Response to Planning Application

From: Arun District Council Greenspace

Application ref: Y/123/21/PL

Description: Variation of condition imposed under Y/82/20/RES - following outline consent Y/80/16/

Play Area (LAP 1) - Scale 1:100@A1

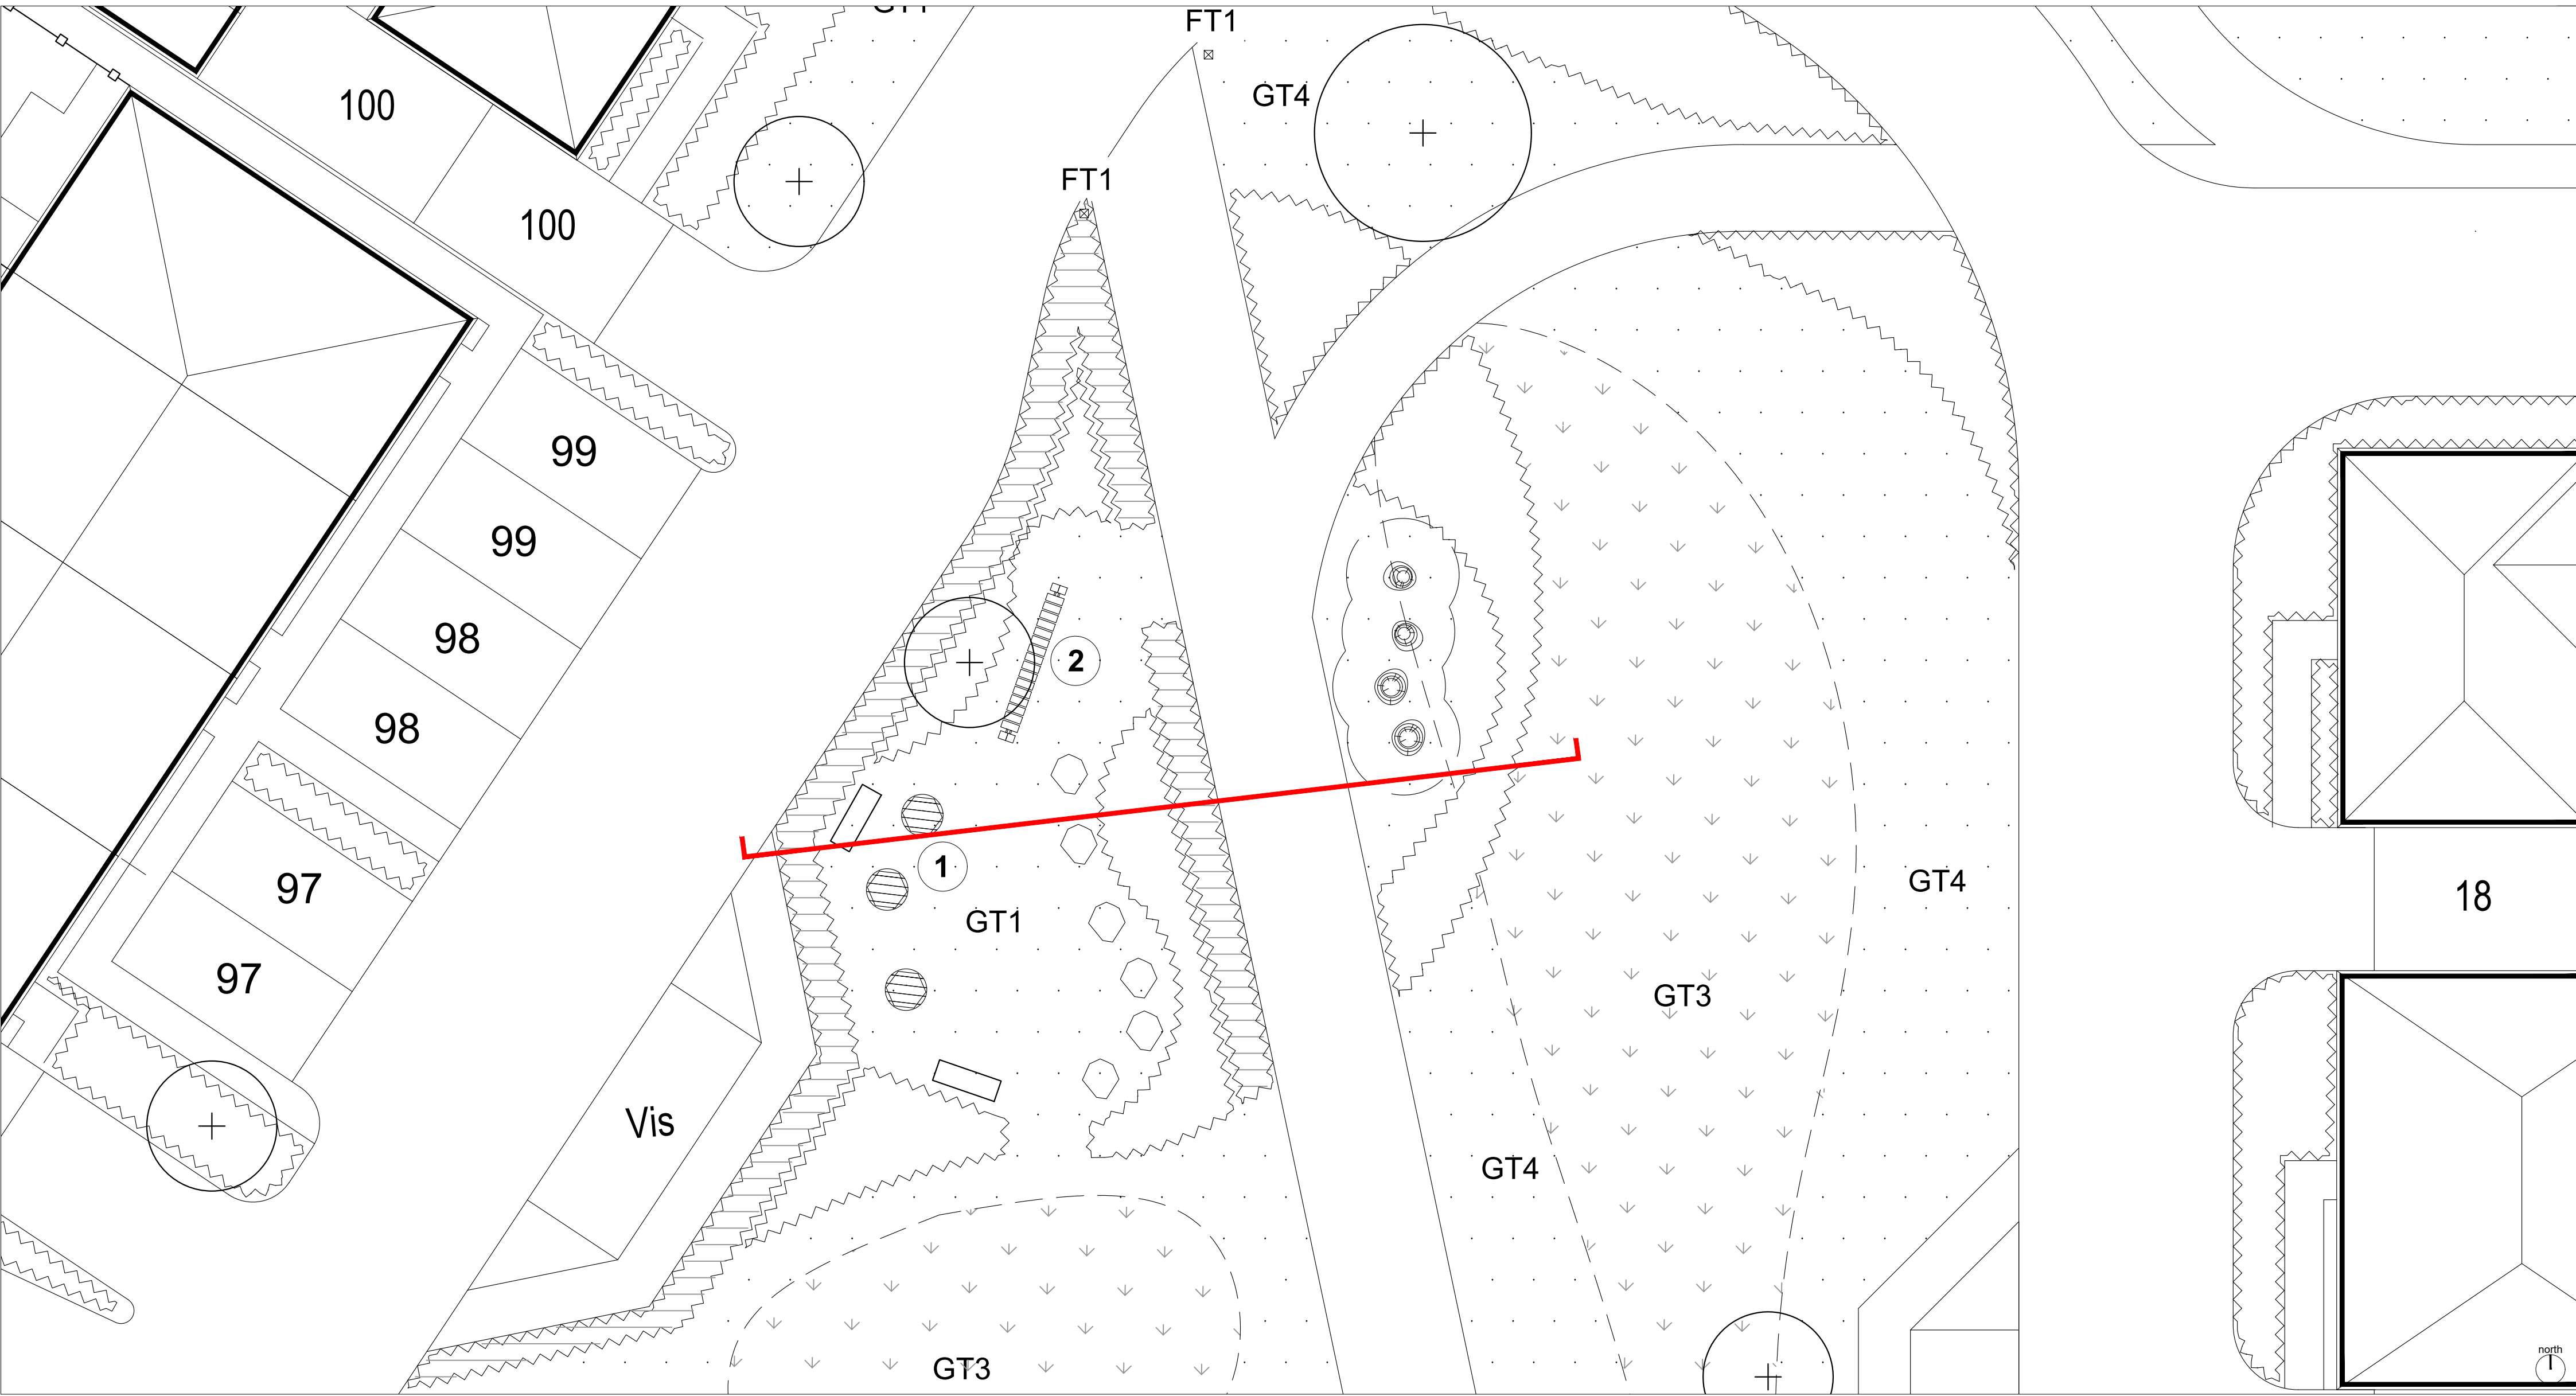
- Pathway surfacing is also not detailed to the LEAP and LAP play areas, this needs to be shown and again due to high use needs to be Tarmac in finish. Pathways shown as grass mown paths would not be considered good choice within the POS areas as they invariably do not become mown paths within the maintenance undertaken. Any formal pathways need to be suitably surfaced and in the POS periphery area of grass, permeable pathways ie should be considered in favour of mown grass paths.

Play Area (LEAP) - Scale 1:250@A1

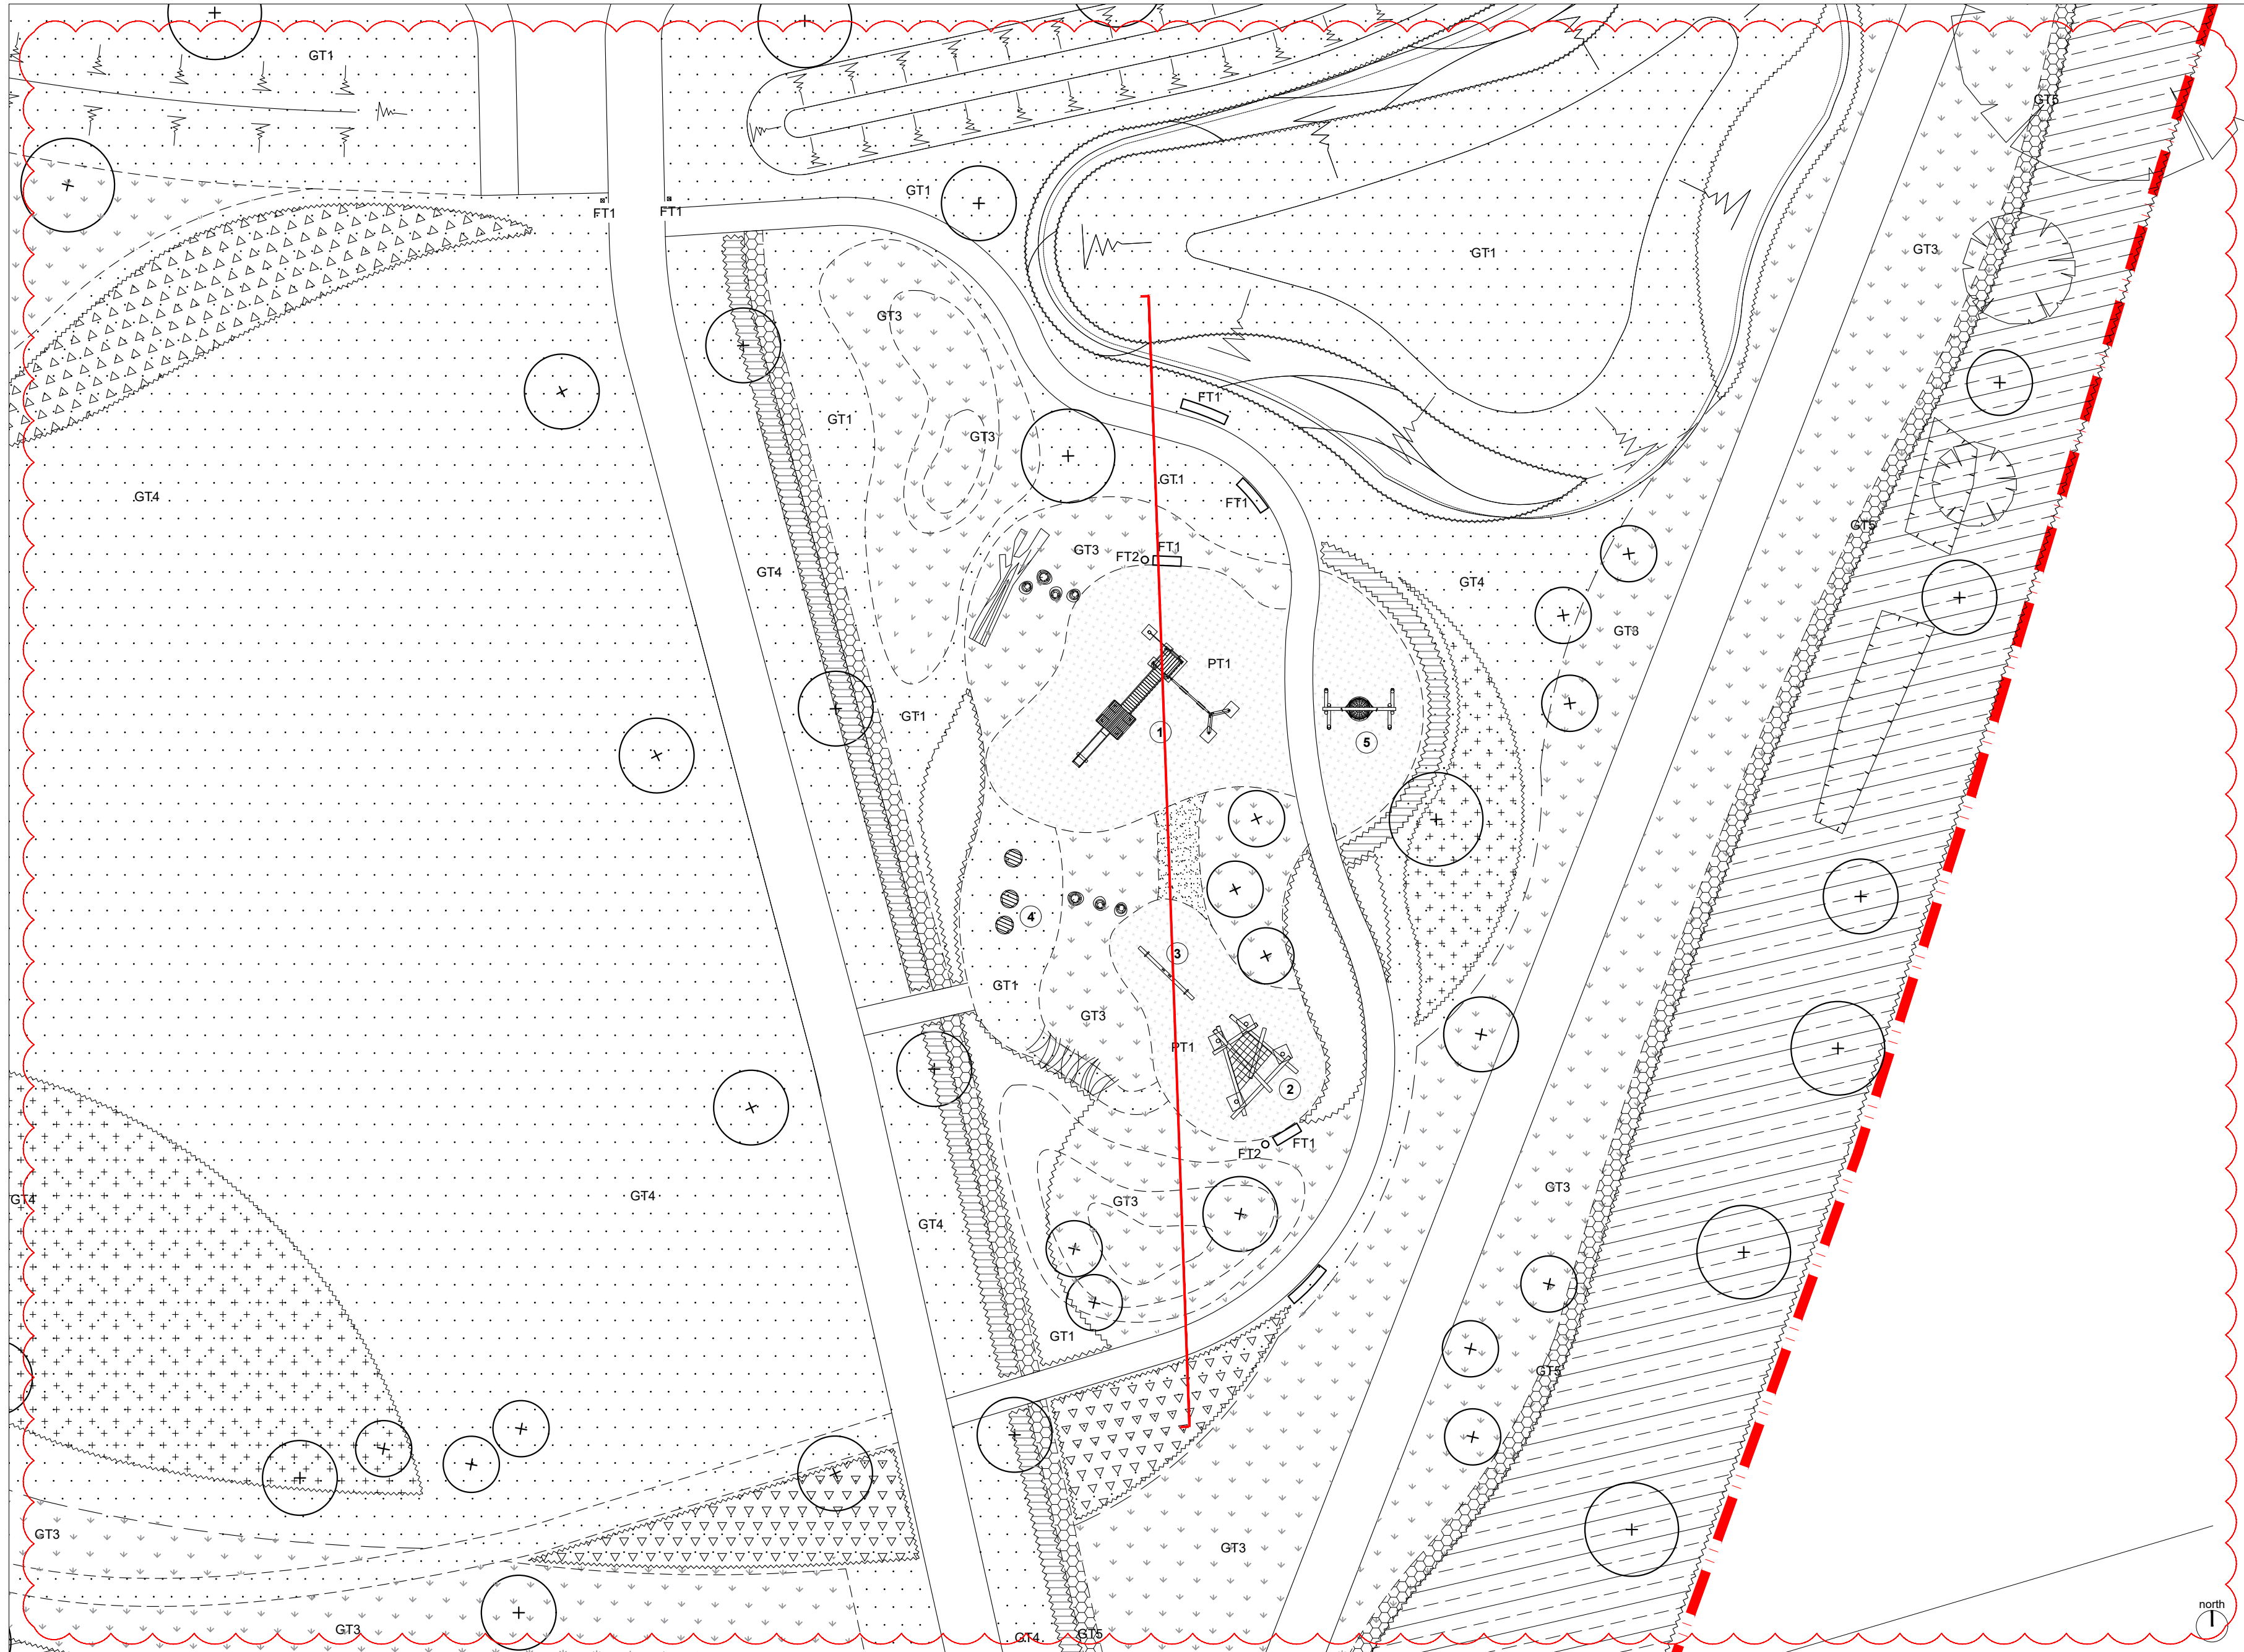
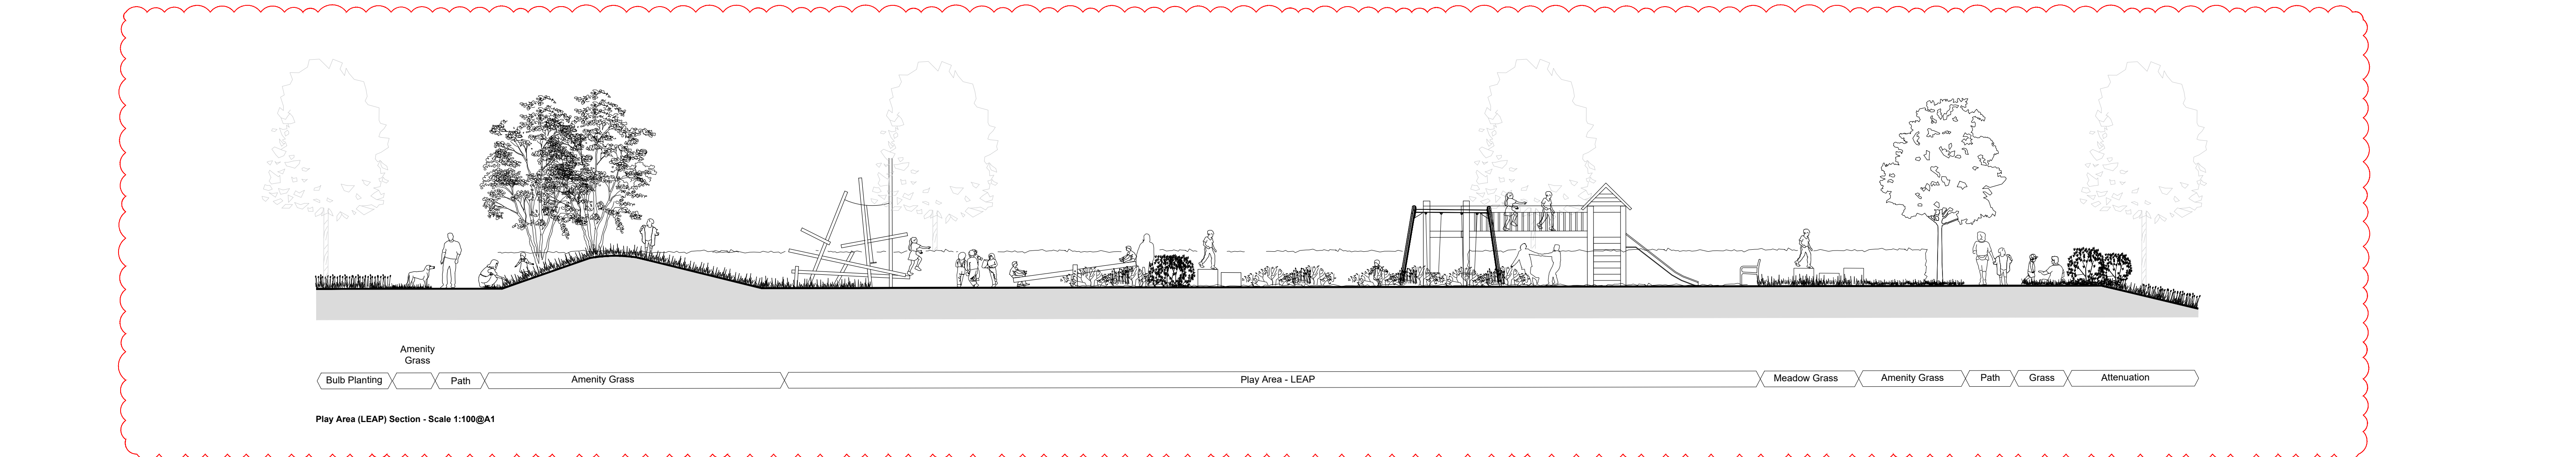
- There appear to be inconsistencies within the issued drawings re detail, these need to be consistent showing the correct detail and specification.
- The Coloured Landscape Masterplan D2831-FAB-00-DR-L-0100 REVPL13 and associated drawings now show a revised layout where the LEAP has been relocated to a position adjacent to the SuDS feature which is detailed as pond and which the cross sections show this to be a considerably significant depression basin and potential to be water holding. This new LEAP location shown is to the south/east corner of the development, appears squashed into the space between the SuDS and the pathway and is in a location which does not afford a good level of surveillance. There are items of play equipment which border very close to the SuDS and pathways in close proximity also.

- **Recommendation is to relocate the LEAP back to the south/west of the pathway and away from the shown SuDS basin and in line with the previously agreed position. Play in this area would connect it to the surrounding greenspace without the need to cross the pathway and in an area which is more visible.**
